August 5, 2022

Re: Cherberg Dock, PRE22-030, SHL14-031 & Building Permit 1501-218

SHEET A3.0
NWS-2021-XXX
PAGE 3 OF 11

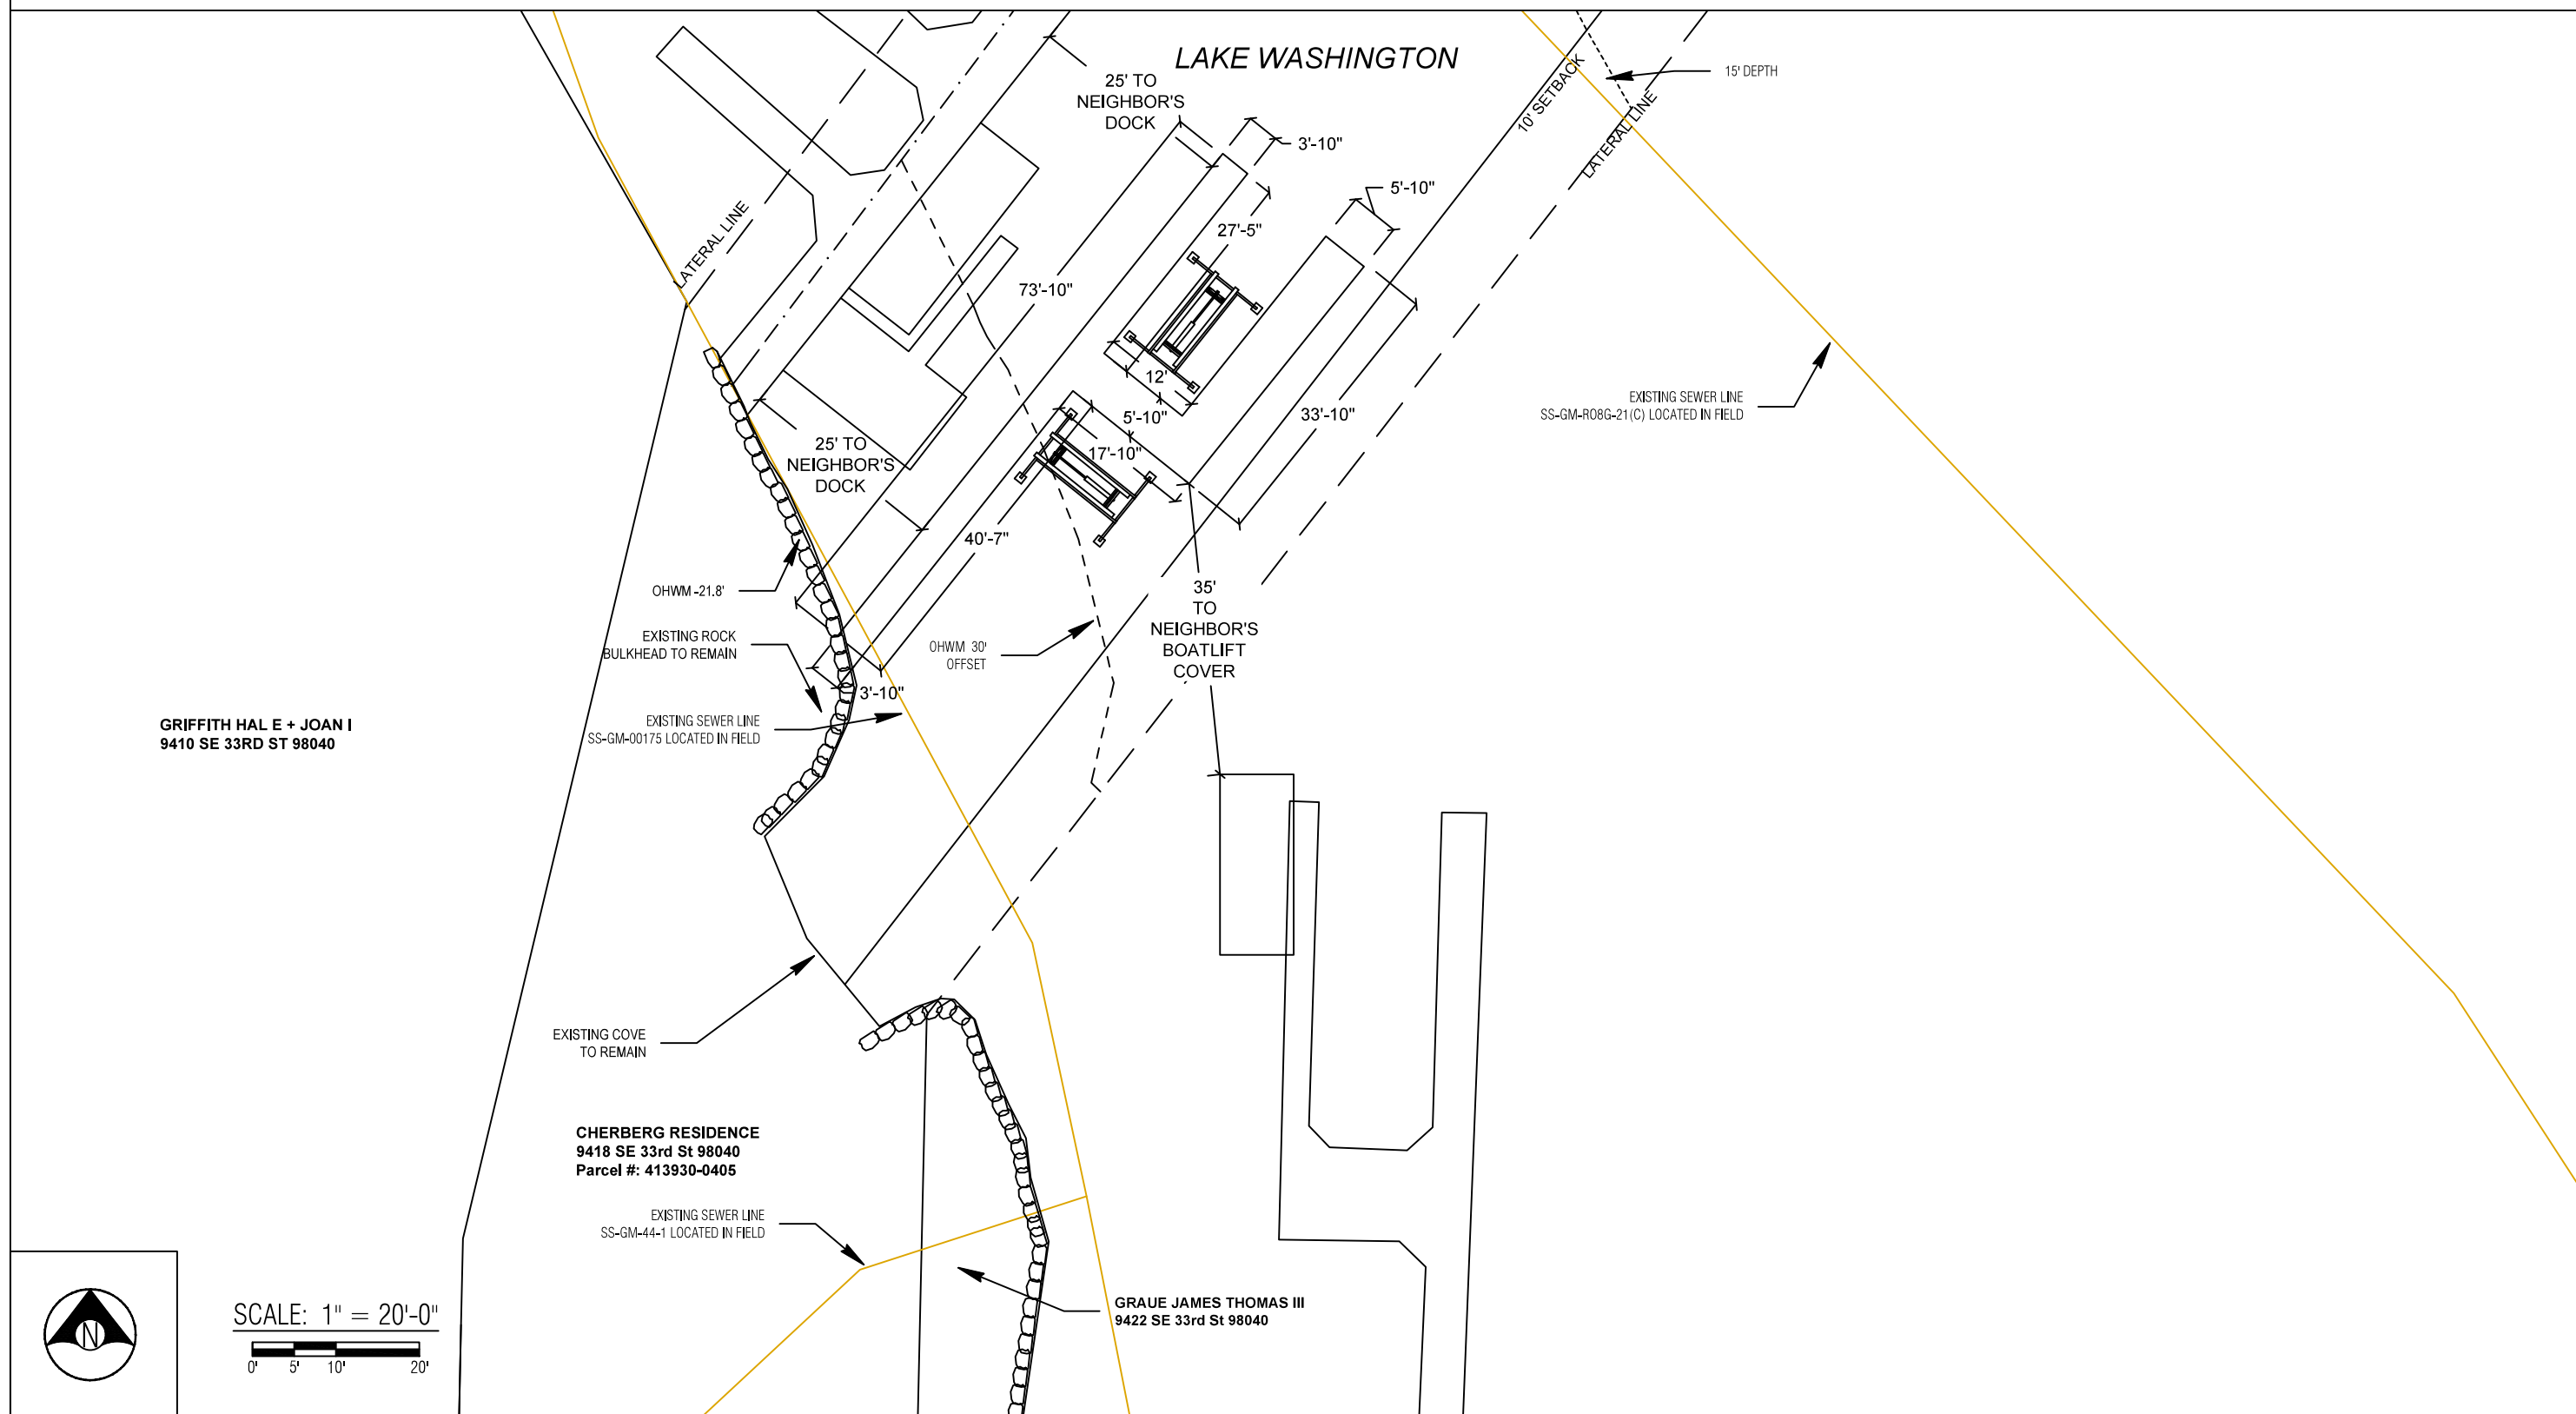
My client has seen various drawings over the years, many of which appear inconsistent with each other with respect to the exact location of the proposed dock and its relationship to the various existing structures and setbacks. For example, the scale and the distance between the Graue & Griffith docks does not appear to be the same from design to design. What design exactly is being reviewed now and what is being done by the plan reviewer to validate the various distances?

Most importantly, the proposed dock is a hazard to safe navigation into and out of the Graue dock because it extends out beyond and cuts across the northwest half of the Graue dock at an angle. It is a hazard because of the close proximity of the proposed dock the fact that it angles towards the Graue dock. Because of those conditions, it severely limits maneuvering

space in a critical location northwest of the Graue dock. This portion of the lake is very active during summer, generating large and continuous wave action and wind, both primarily from the northwest, at the very time of year when the docks are in use and safe navigation around the Graue dock, slip and lift is required. The Graue dock has a sizable slip (16' x 42'), and they have had upwards of a 46-foot vessel docked there. Navigation of any vessel, let alone a vessel of this size, would require more navigation room north and west of the slip for safe departure and approach maneuvers than the proposed Cherberg dock will allow. In short, the proposed dock will impact the Graue's ability to fully and safely access their dock now and in the future. These problems normally do not exist with docks that are parallel to each other, even when they are of different length. But because of the angle and length of the proposed dock, it is highly problematic. Any Cherberg dock needs to allow the Graues the ability to safely accommodate the size of boats the Graue dock allows, and the space to safely maneuver as part of the overall use consideration. It does not.

MITIGATION PLANTING PLAN

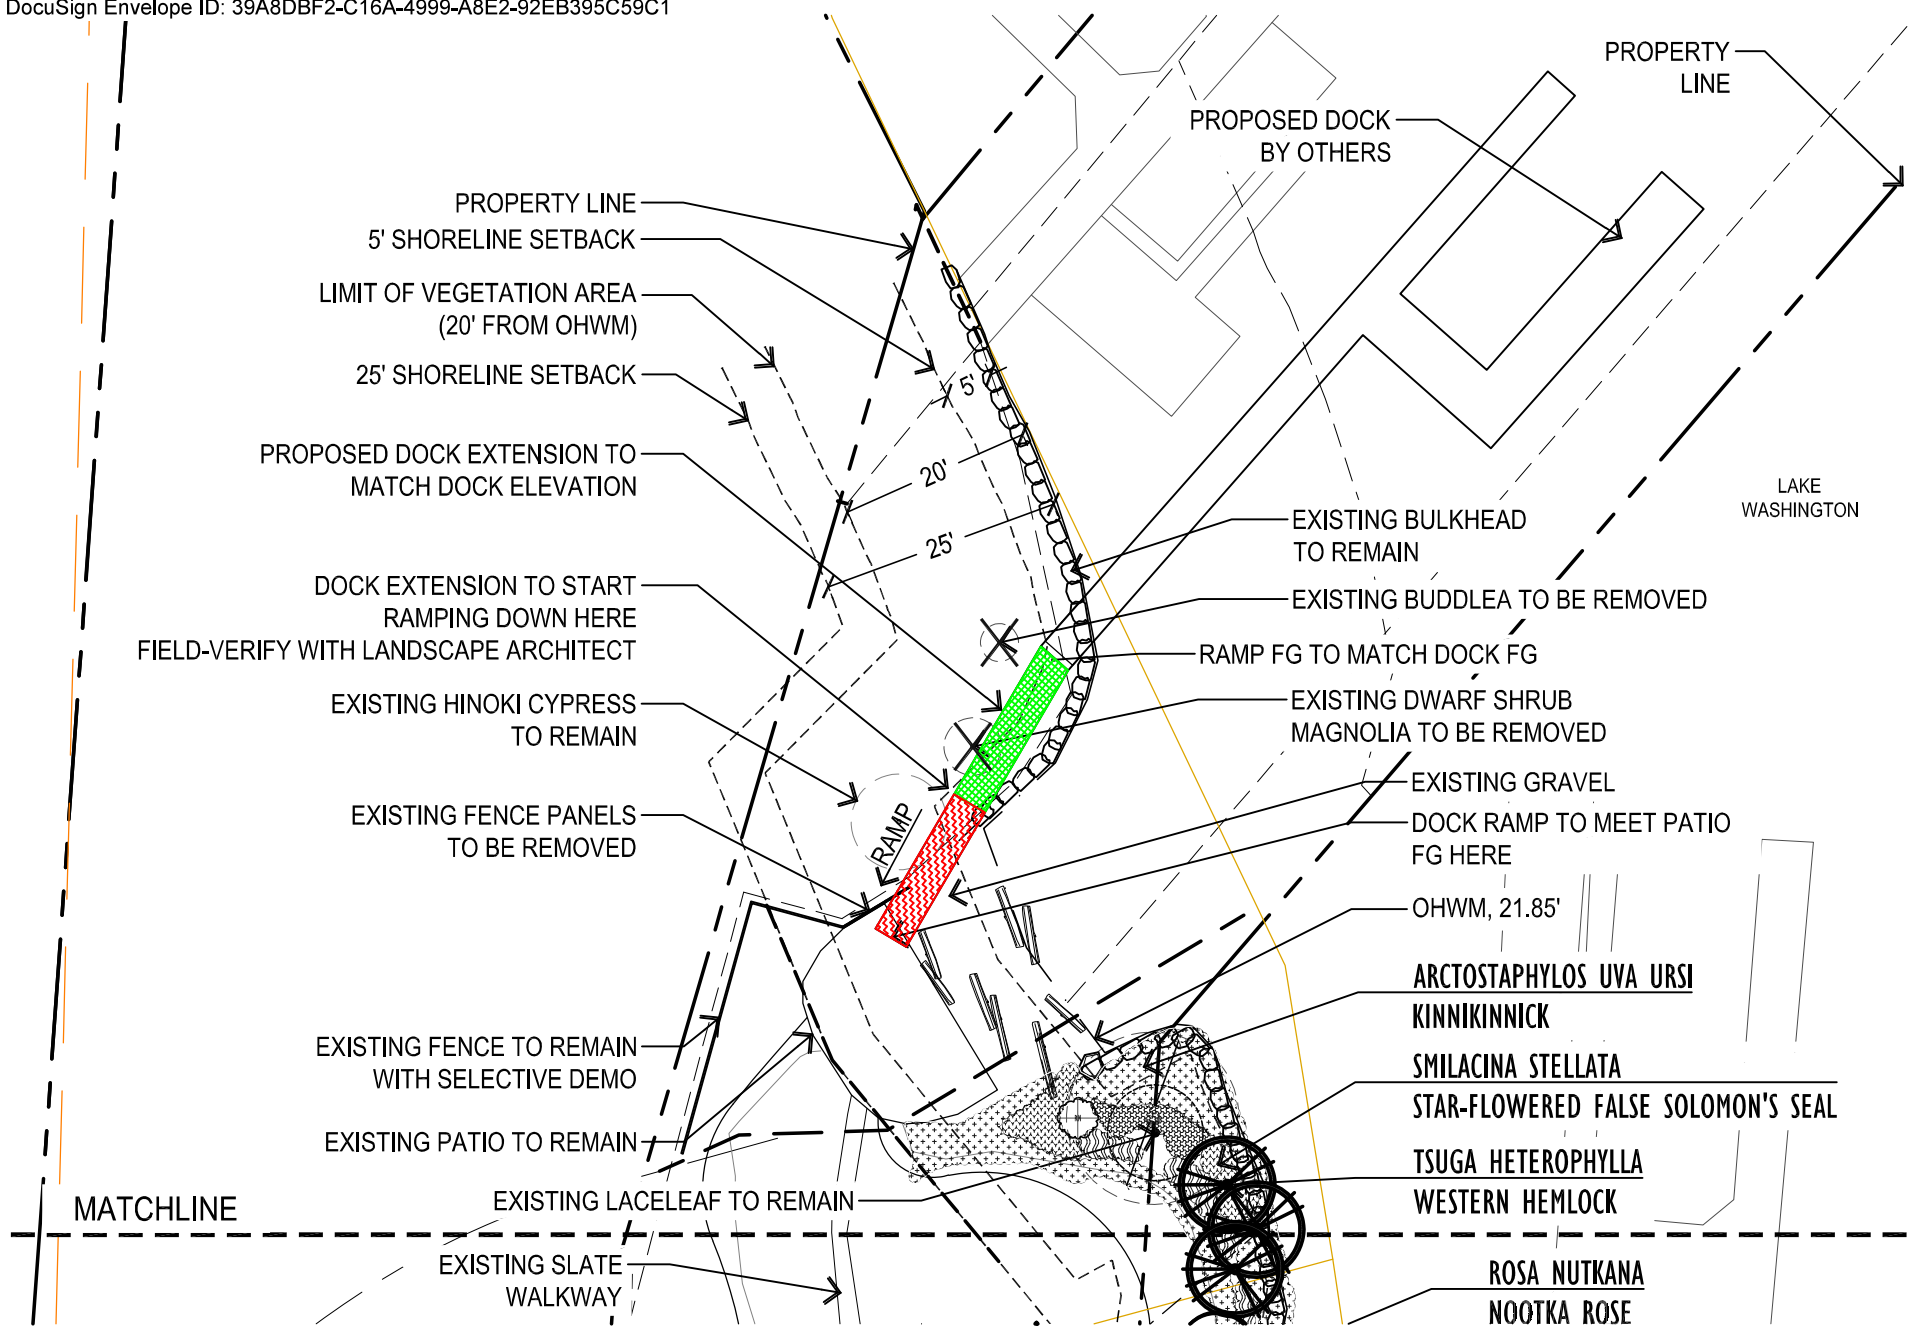
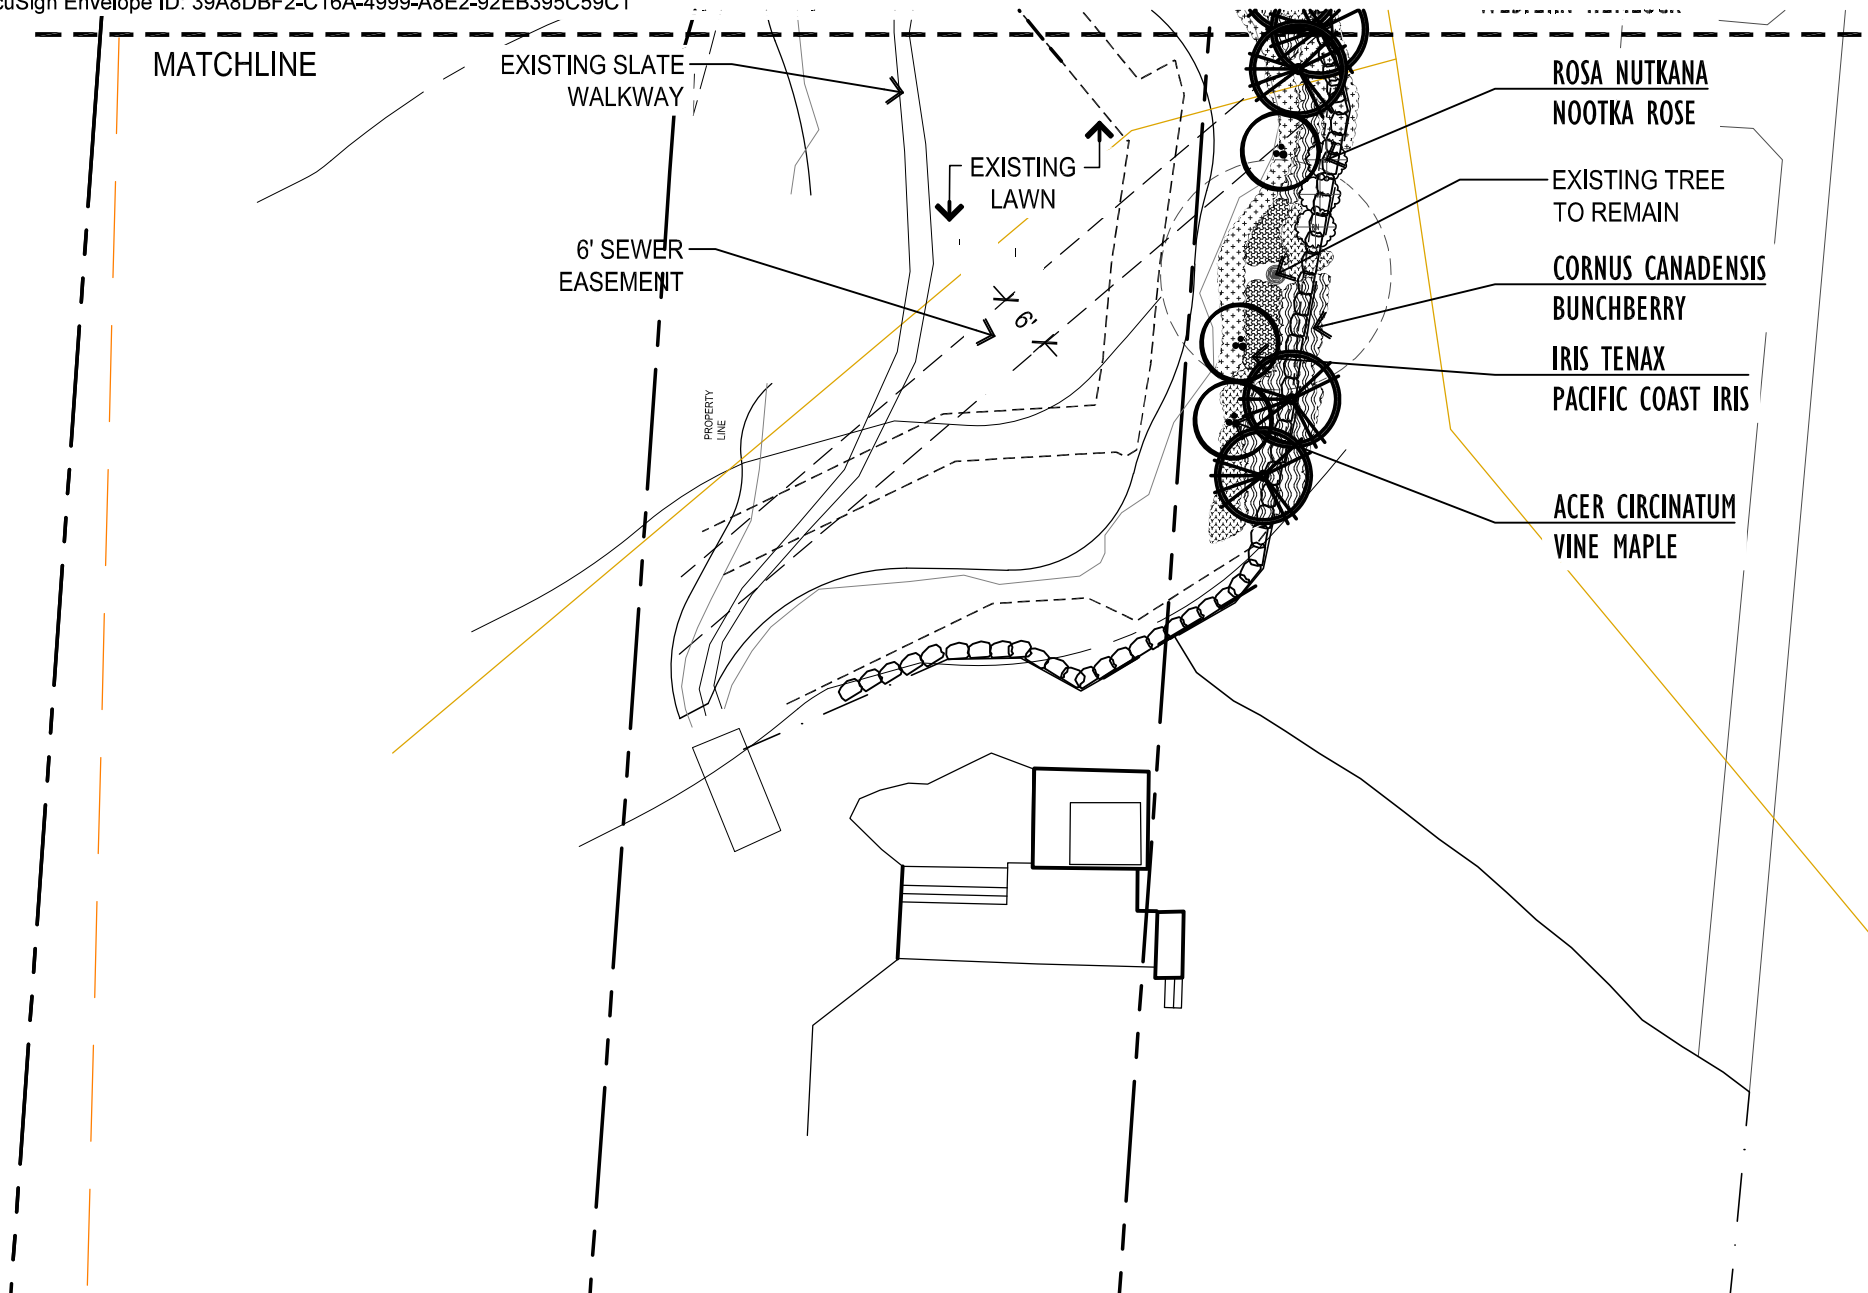
The landscape mitigation plan that I have seen calls for the planting of trees on the property west of the creek. That is property owned by my client. The Cherbergs have an easement to use that area for limited purposes, but, among other restrictions, it prohibits any material changes to the landscaping without my client's consent. *See* attached **Exhibit A**. My client has not consented to the proposed landscaping plan. They have not even been asked to review it. It is not clear to me on what authority the Cherberg's have submitted the landscape plan, or what authority the City would have to require plantings on my client's property. I assume the City was not informed of the easement limitations.
